Subject: Planning application 3/2011/0896

The parish council wish to make the following observations regarding this application:

drawing name: EXISTING & PROPOSED BLOCK PLANS

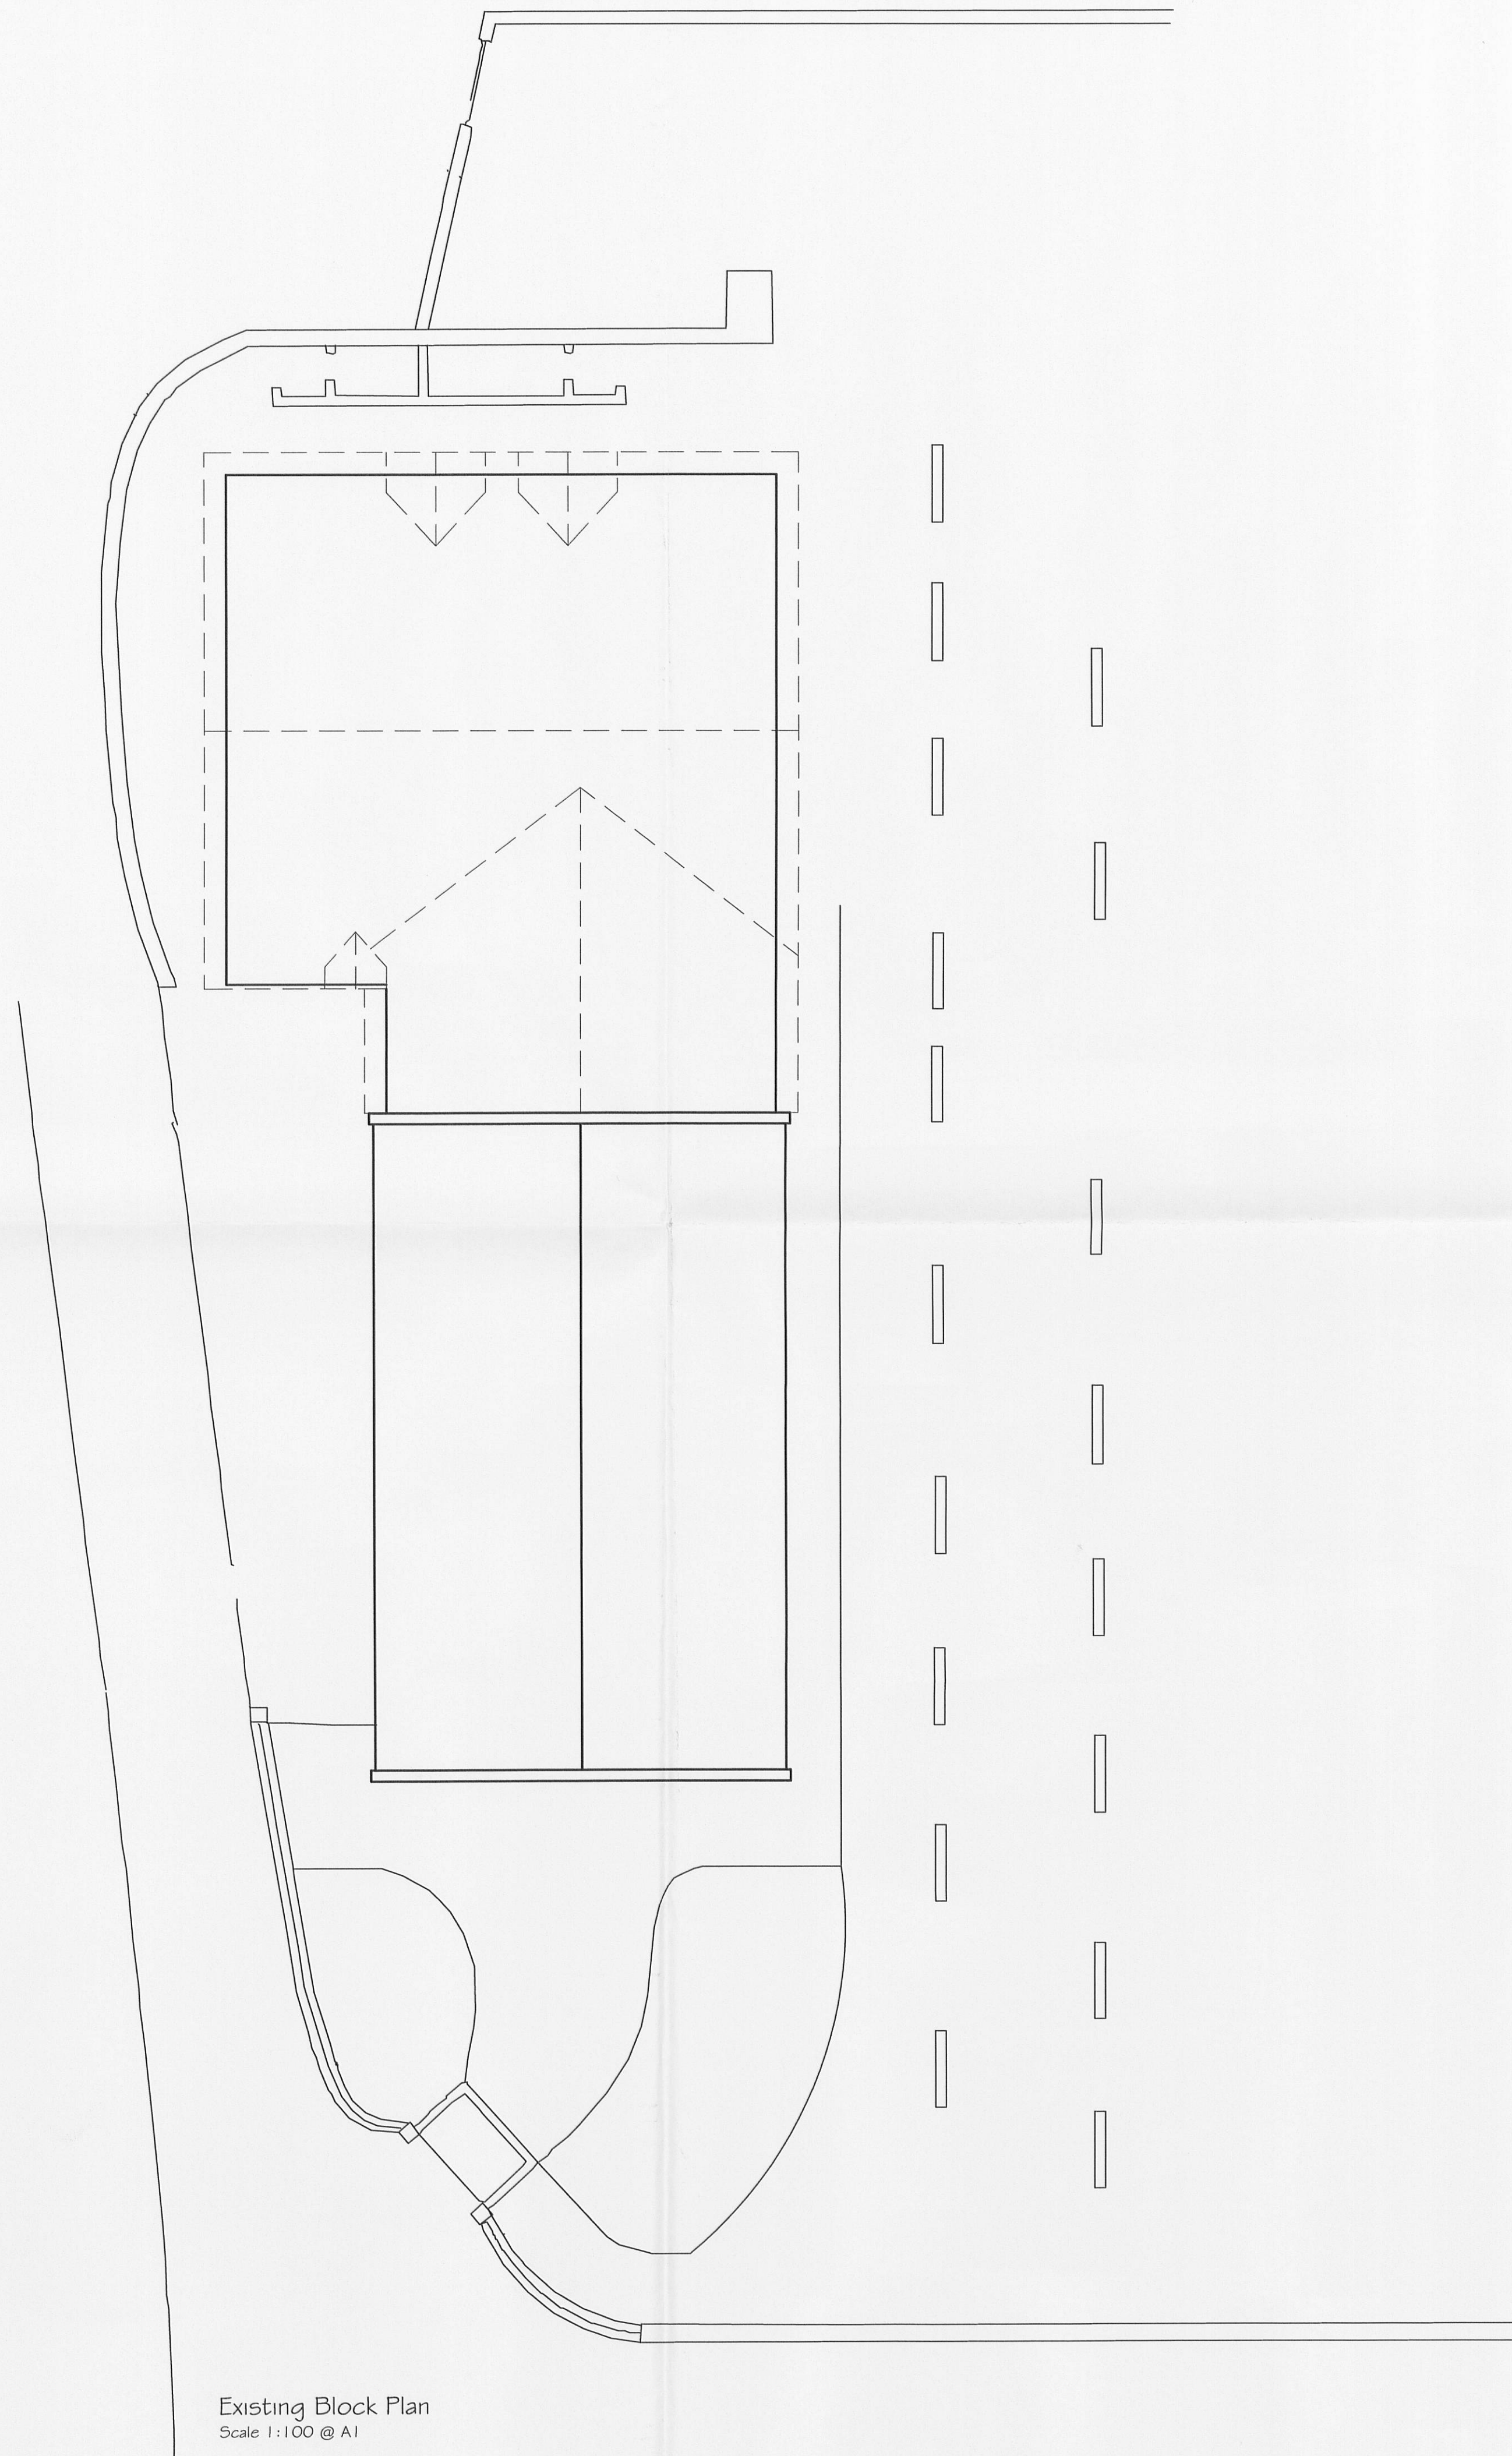
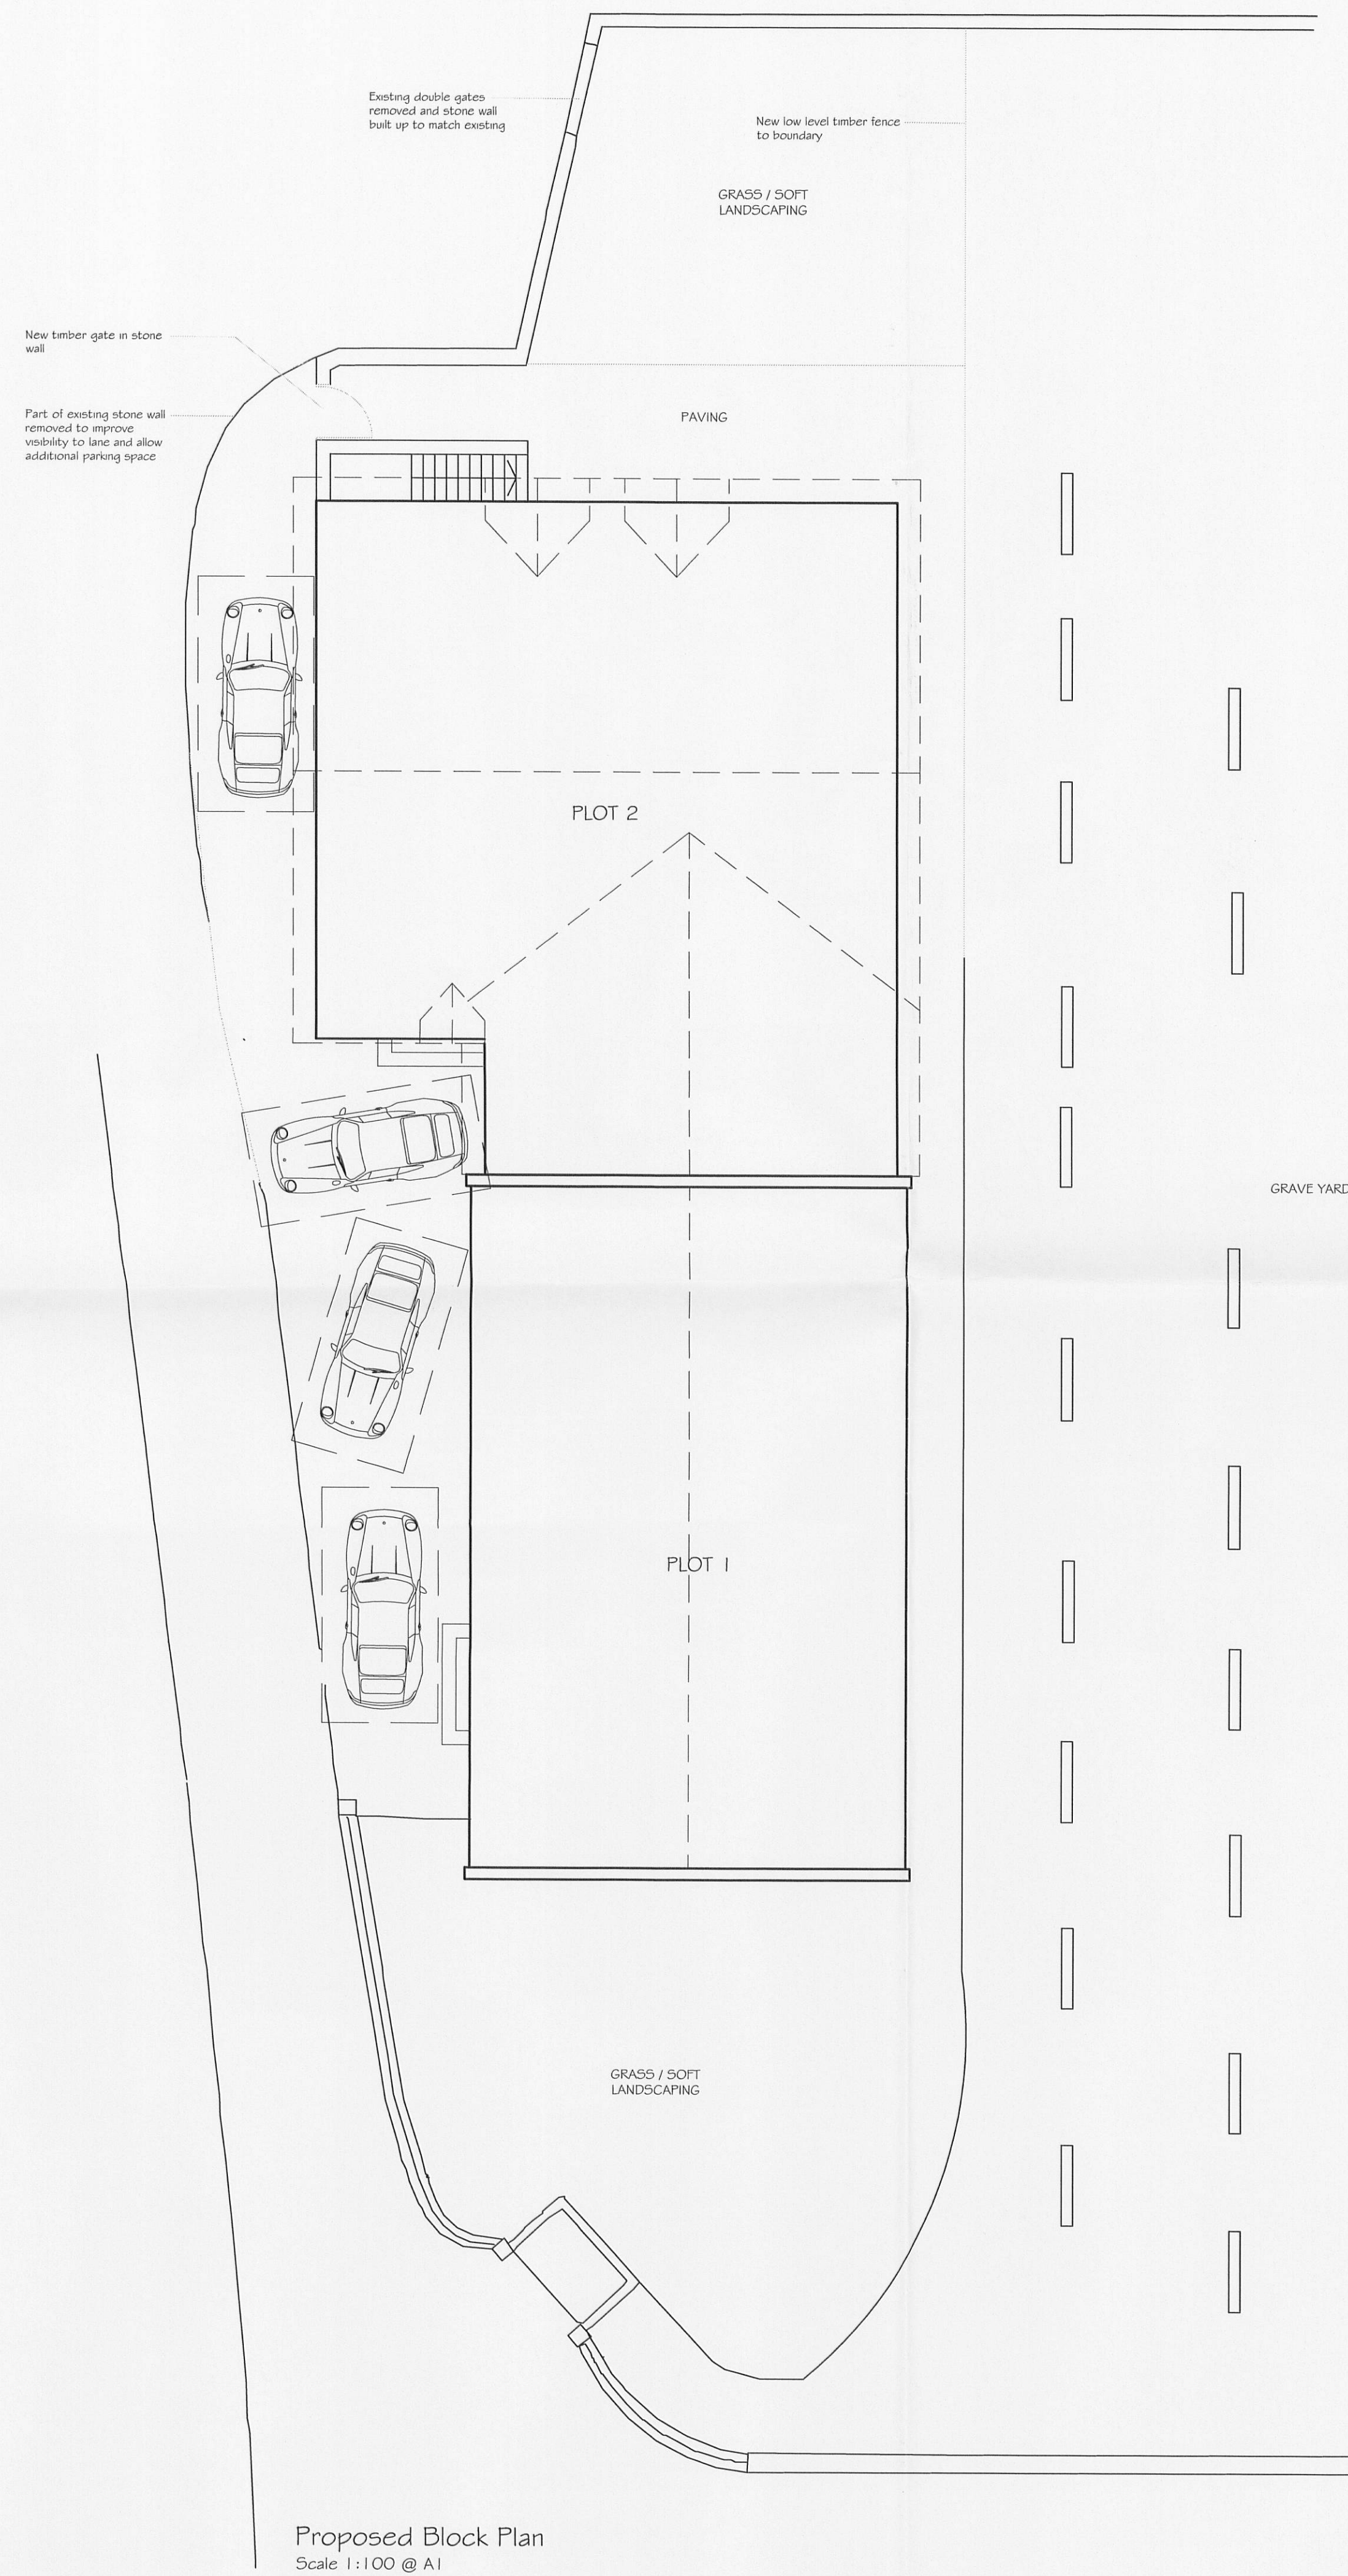
The council was in agreement for a suitable development to proceed. However, several issues were raised regarding the parking.

- The fence erected was not in keeping with the area of natural beauty.
- The council could not support the planned access and egress.
- Vehicles turning and reversing near to the top of Back Lane could cause an hazard. Sixteen properties have use of that narrow and awkward lane. Visitors to the new dwellings could cause severe difficulties.
